Drafted 25 April 2012

**Planning Application, Ribble Valley District
3/12/0308 16 Hawthorne Place, Clitheroe**

Ground Floor Plan

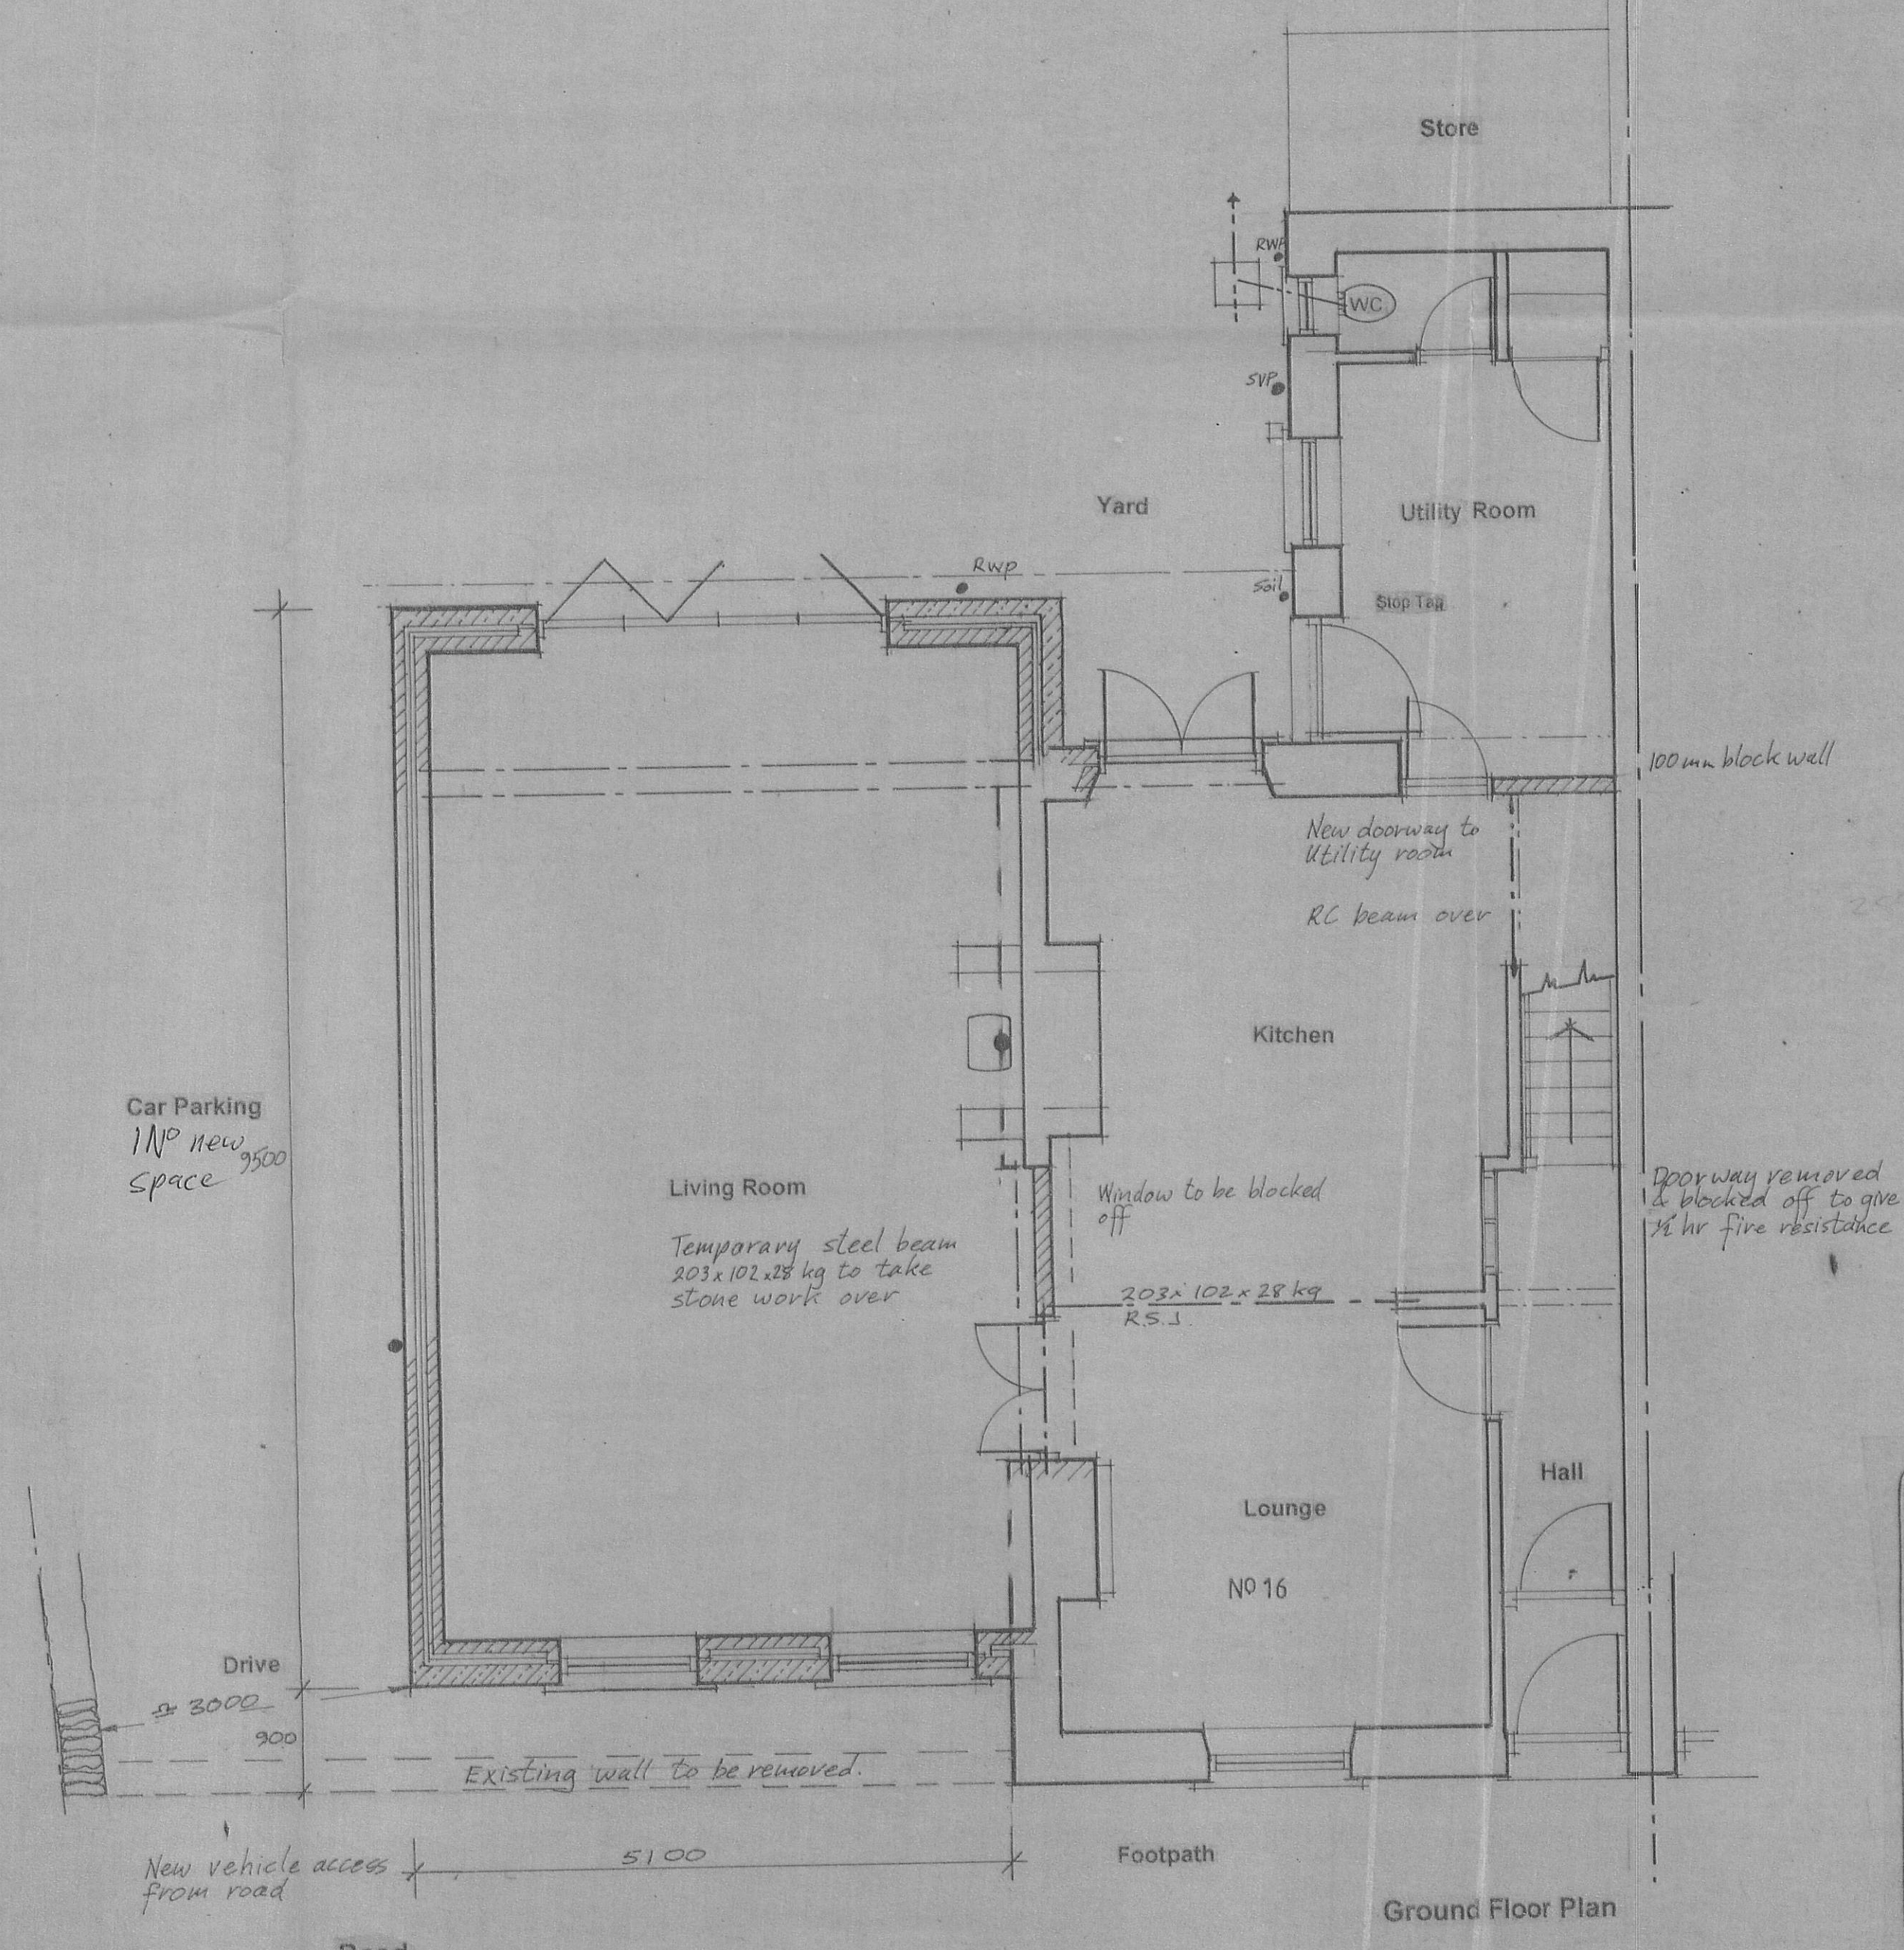
The proposal provides for three off street parking spaces, from a garage and driveway. This is suitable for the anticipated demands of a 4-bed residential property.

However, I would recommend that a Condition be attached to any successful application that seeks to retain the use of the garage for their intended purpose and to prohibit their future conversion to residential living space.
